CITY OF ALBUQUERQUE

PLANNING DEPARTMENT – Development Review Services

November 19, 2015

RE: **Gutierrez Trucking Maintenance Facility**
3006 Todos Santos St. NW
Grading & Drainage Plan
Engineer's Stamp Date ~~8-26-2015~~ (File: G10D036)

SHEET NO. 2 OF 2
GD-2

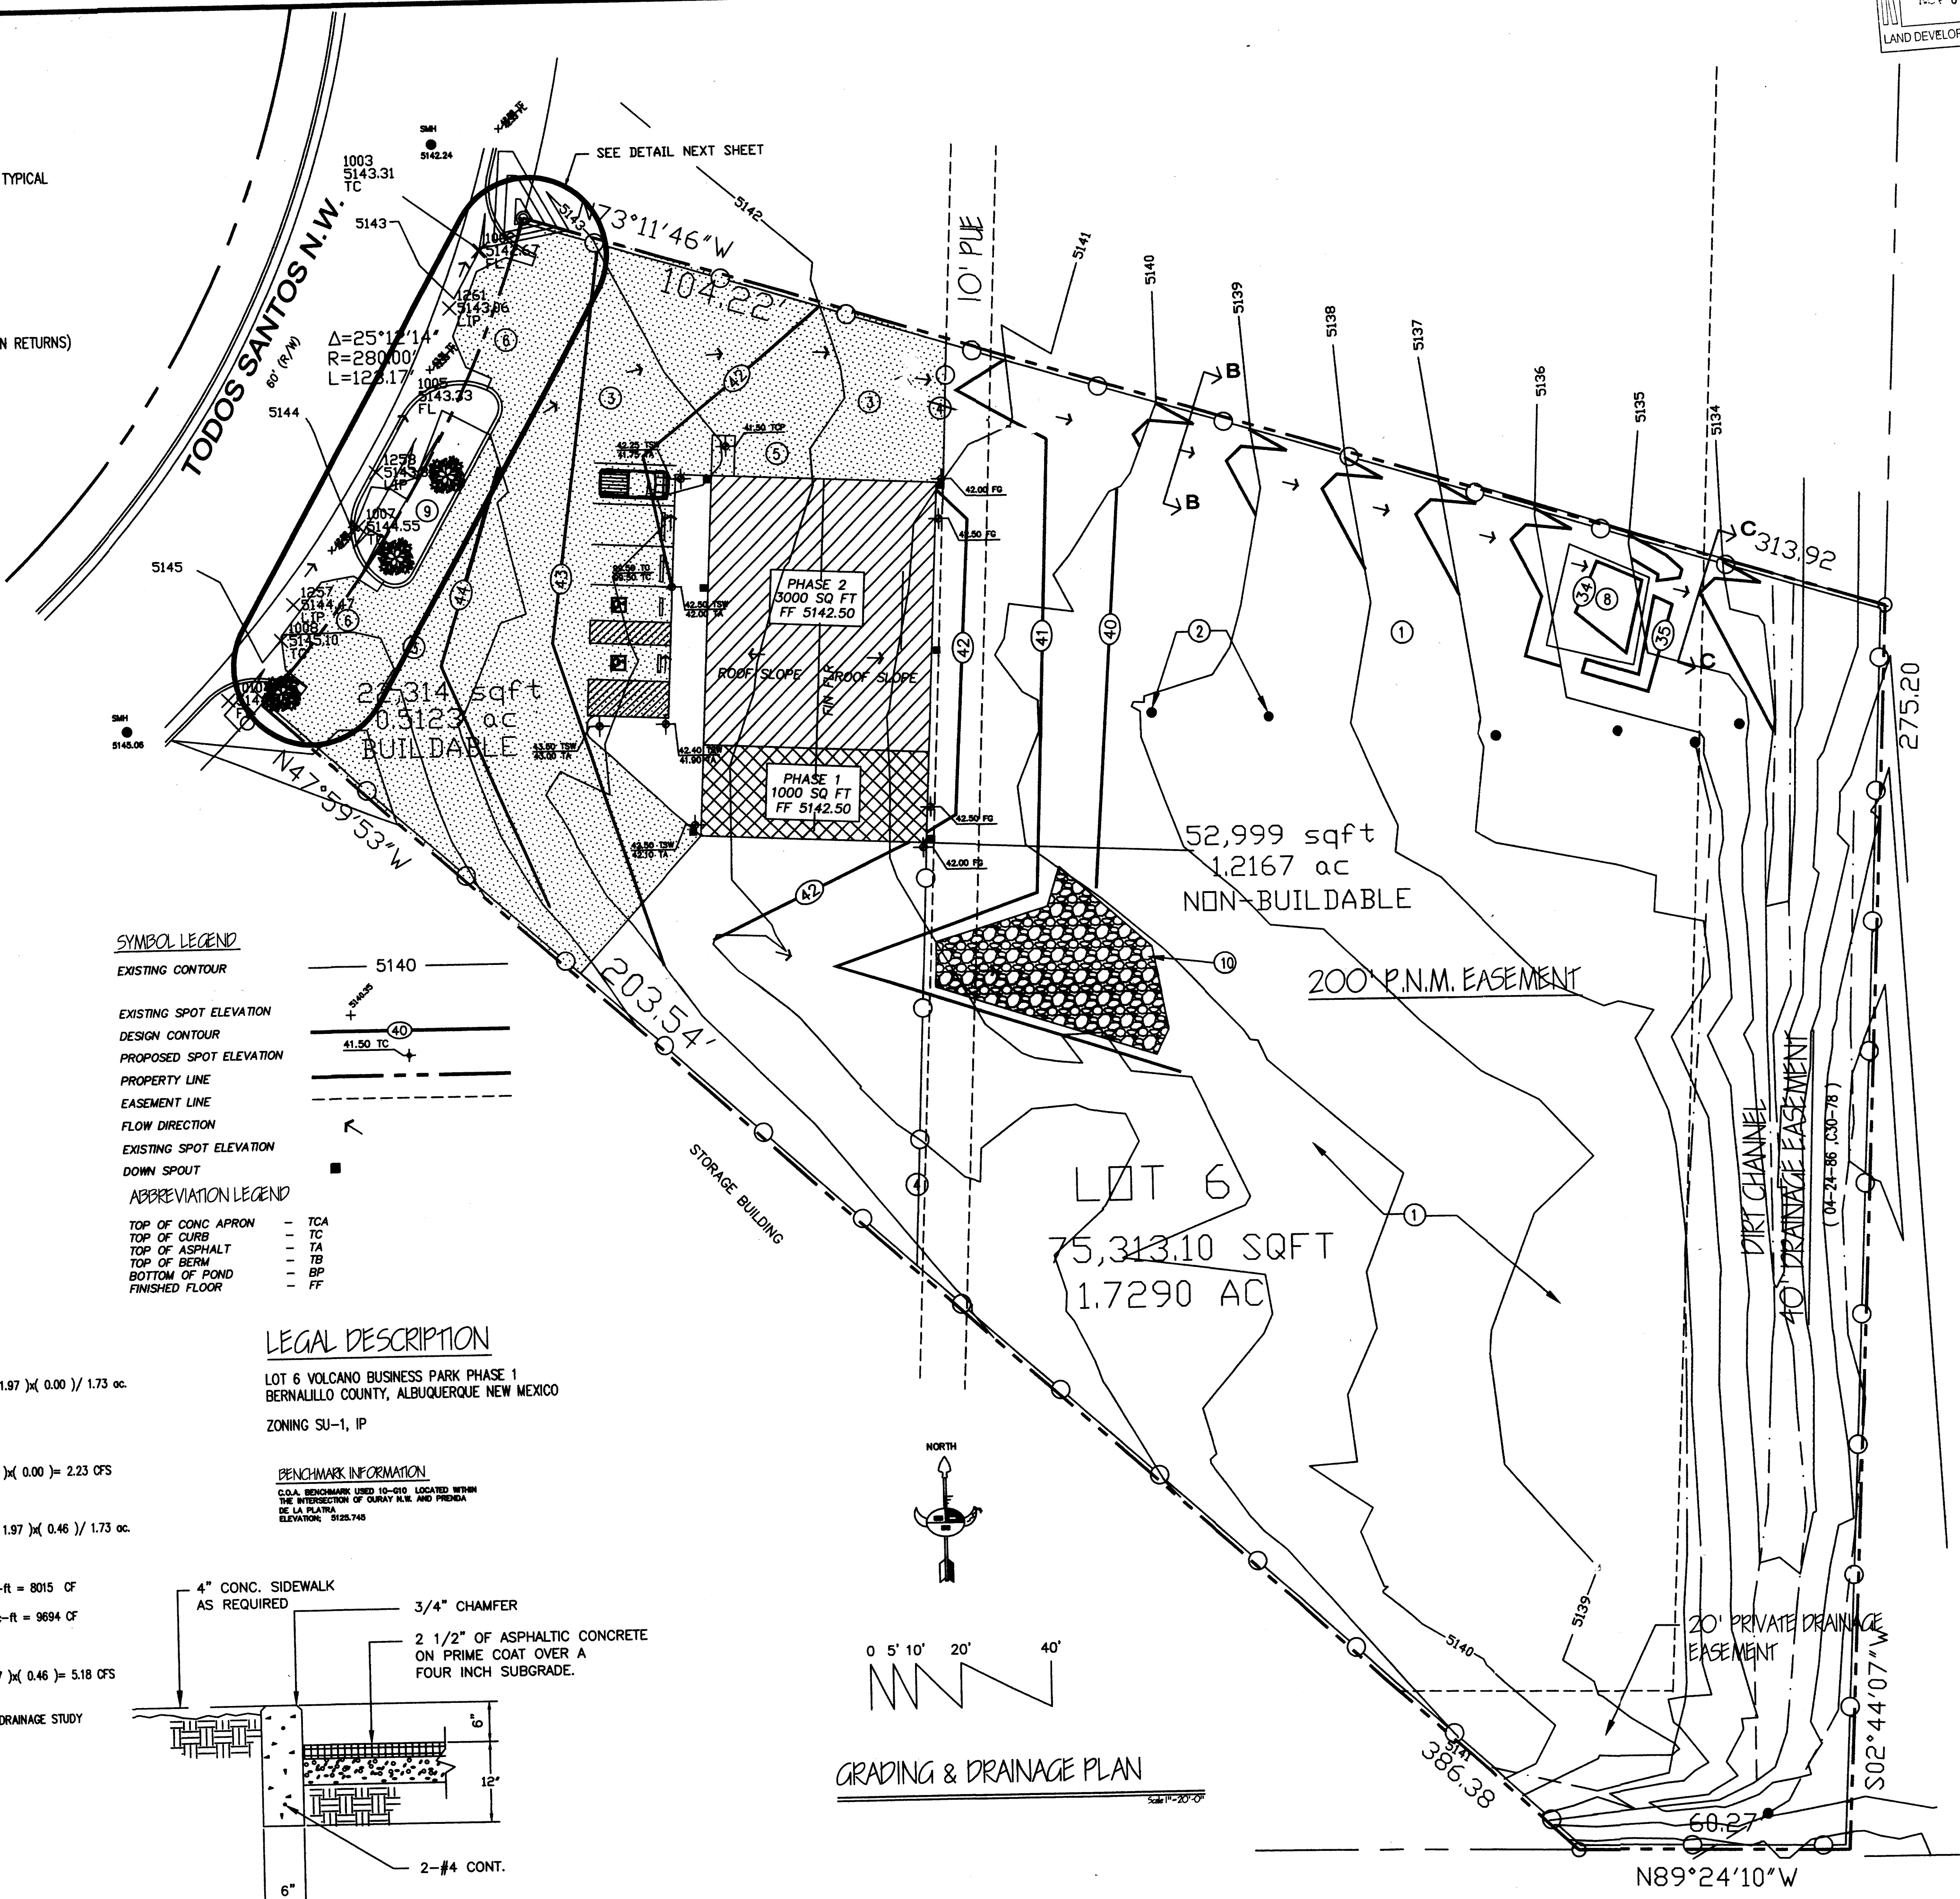
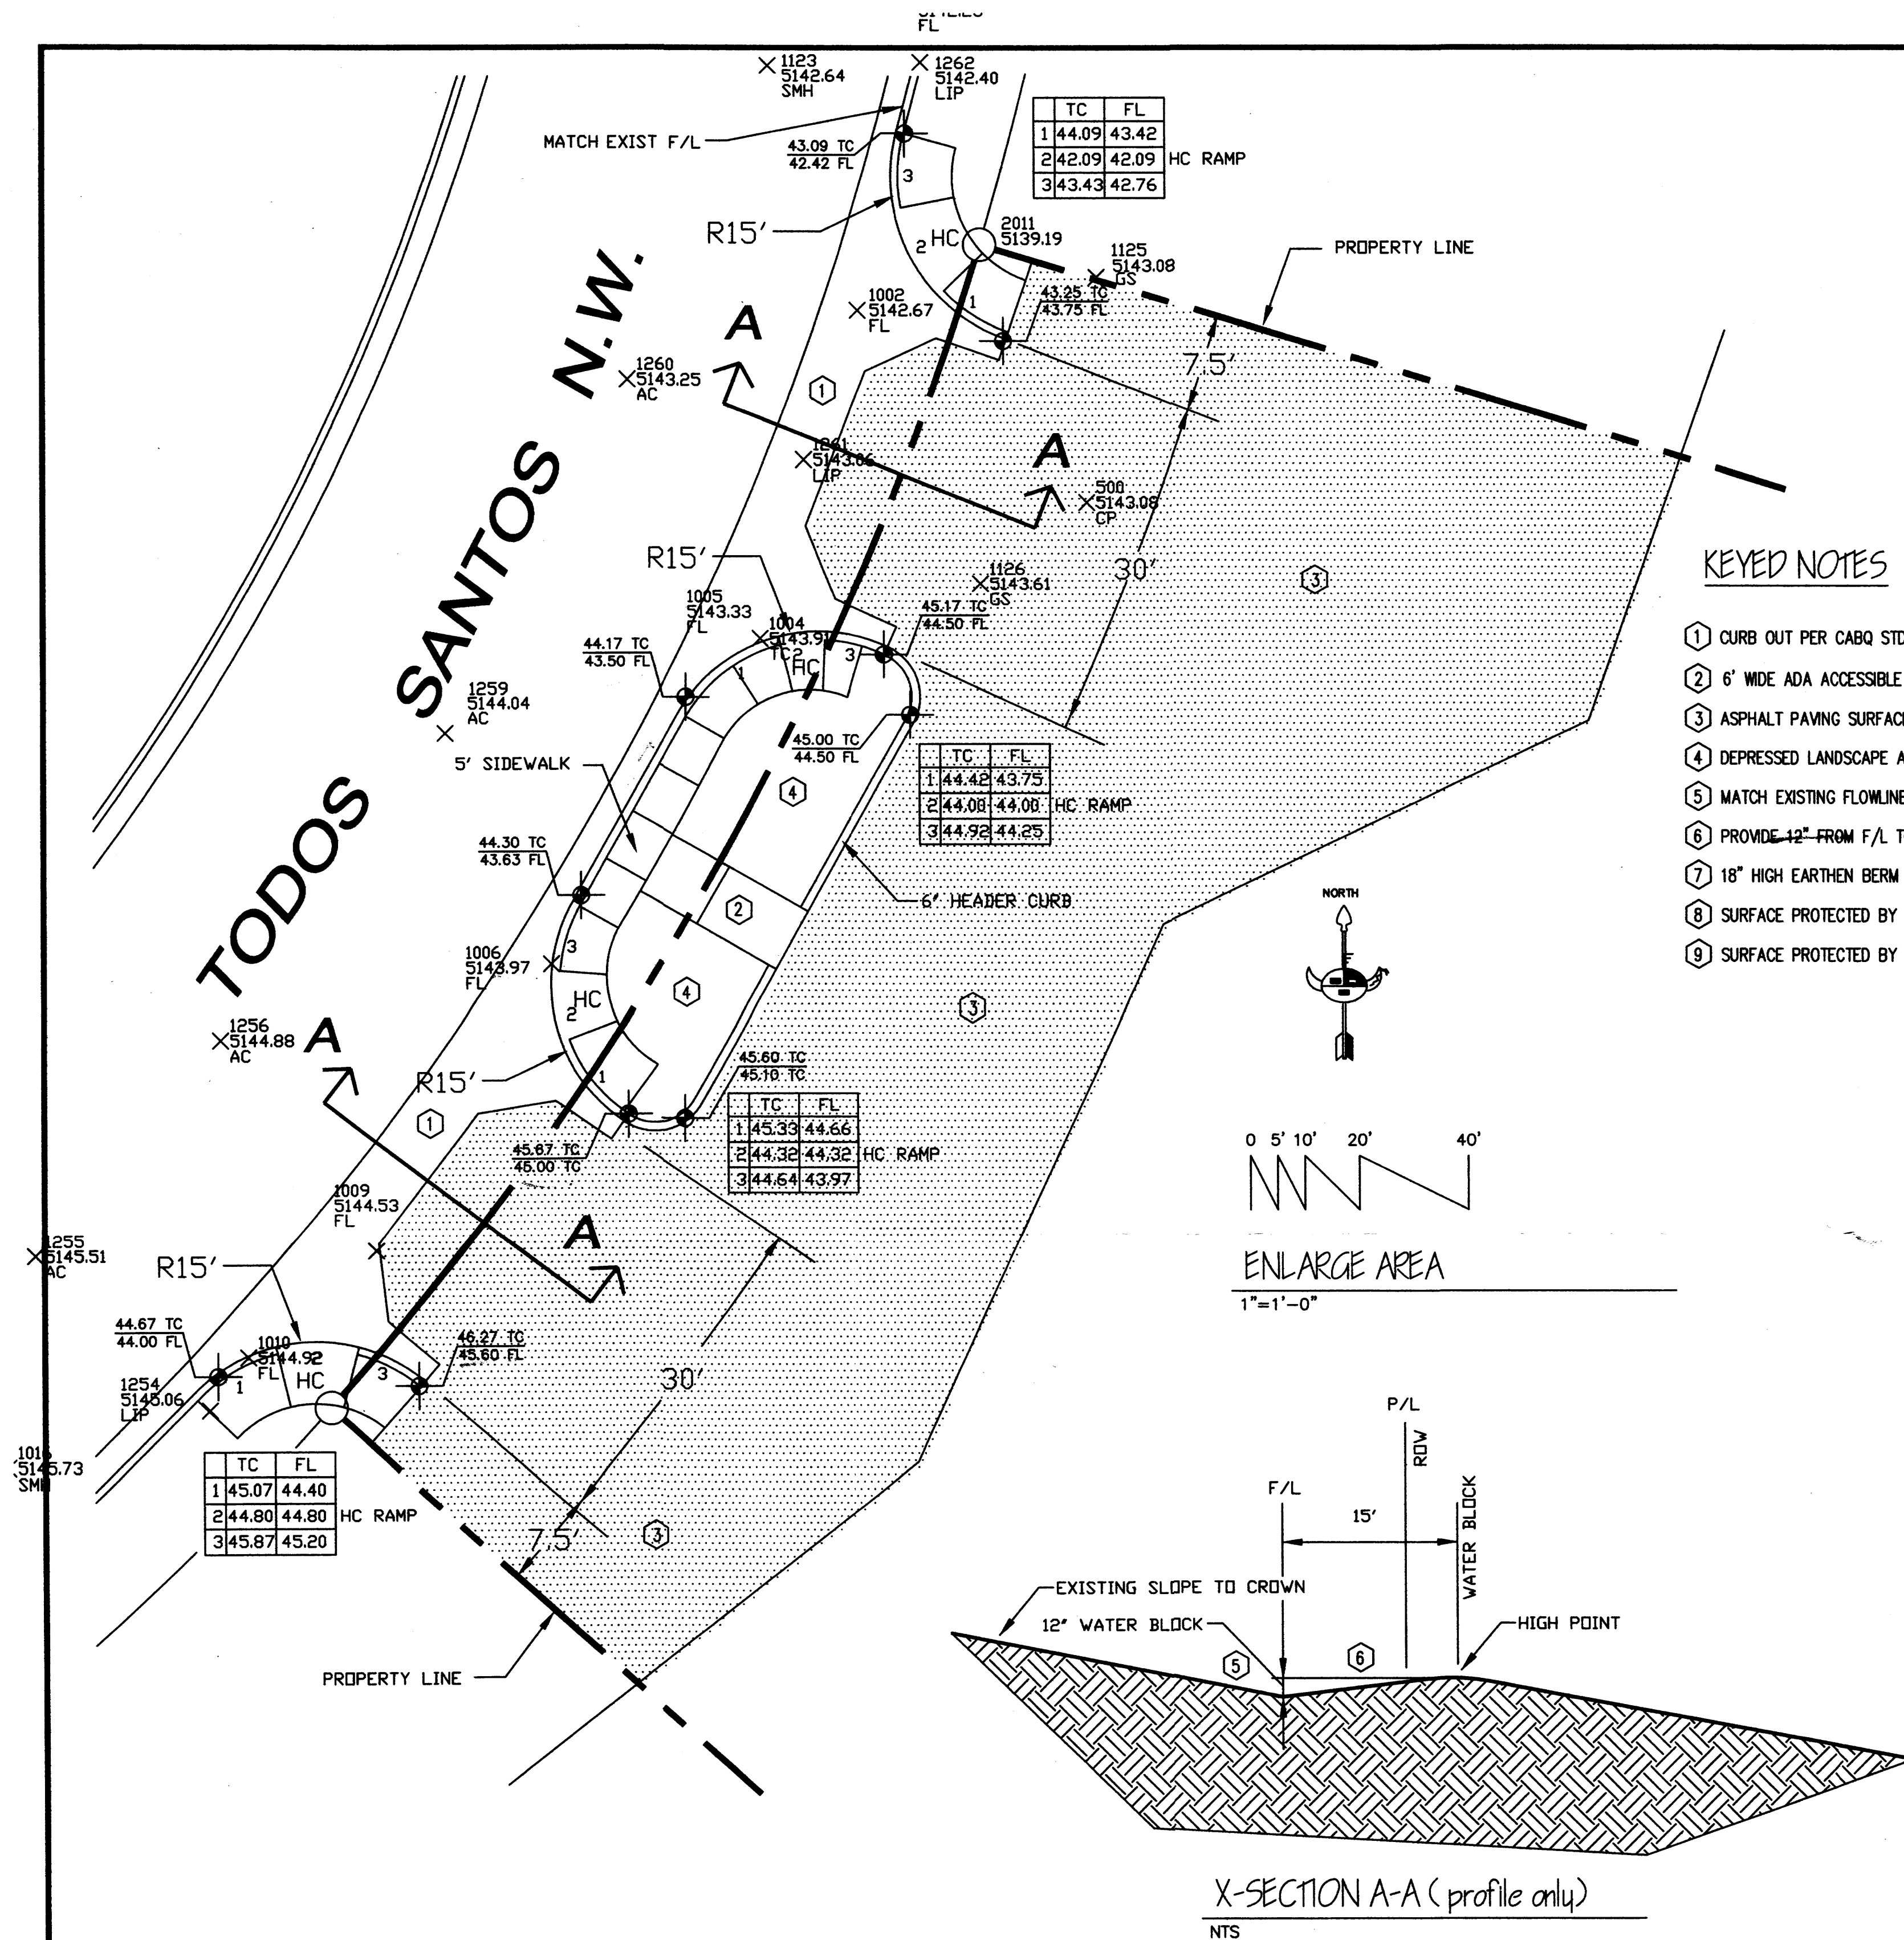
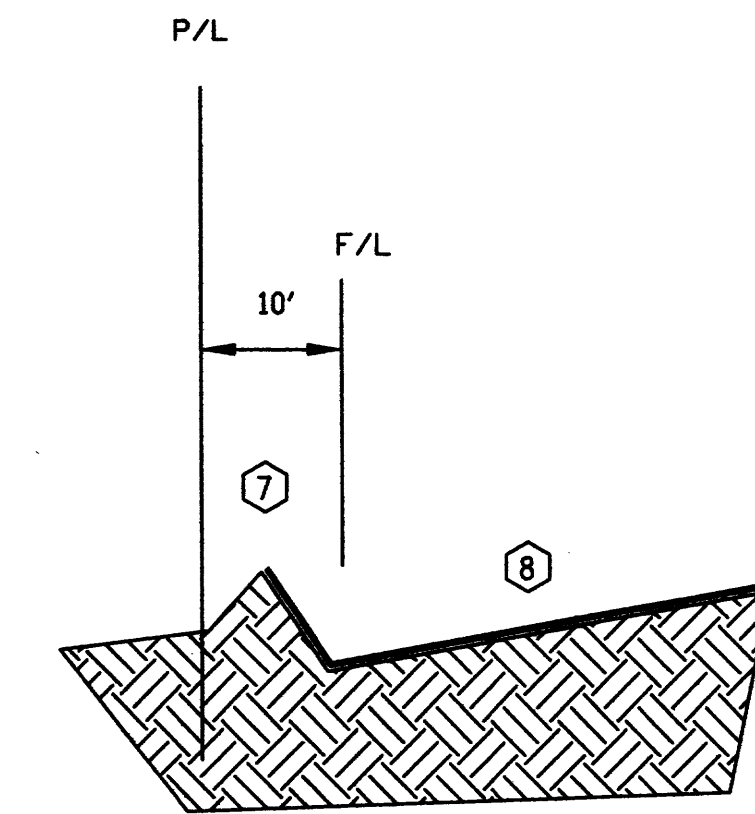
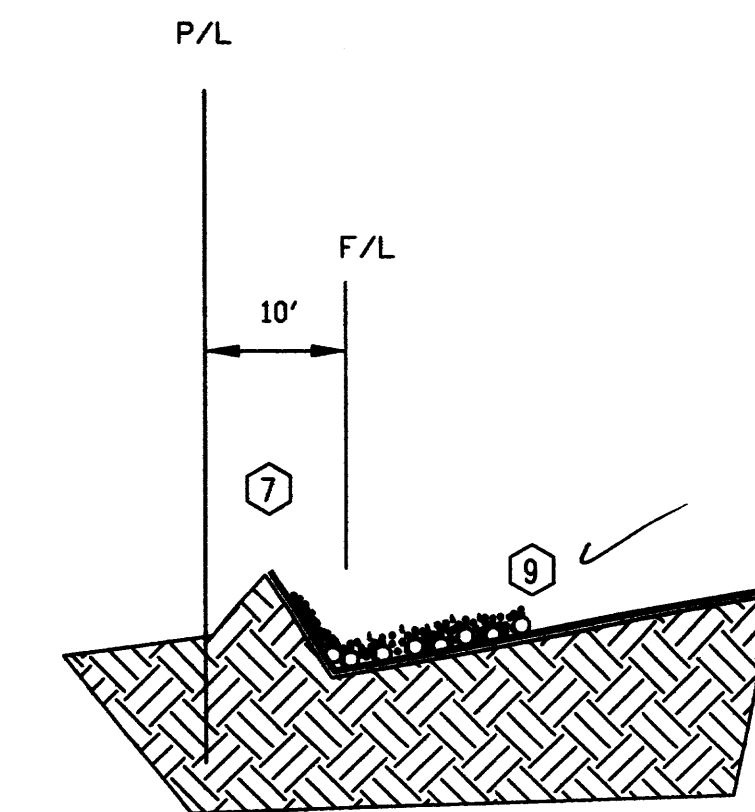
- ✓ 1. Since this project will not go thru the DRC process, the entrances must be adequately detailed per COA Std. Detail 2420. Show existing flowline elevations, quarter point elevations, intersection of flowline elevations, etc. There is overlapping text and line work making the plan difficult to understand in this area. It may be necessary to provide a separate detail. Sheet 2 has been generated to provide separate details for better clarity.

- ✓ 2. Water blocks are not evident. Please use zigzag line to note water blocks. The new details indicate the water blocks with elevations.
3. Provide a section of the swale to the pond and show erosion protection. *A detail has been provided on the second sheet indicating the erosion protection.*

4. Provide erosion protection at the first flush pond, for both discharging and inflowing run-off. *Second sheet shows detail for the erosion protection.*
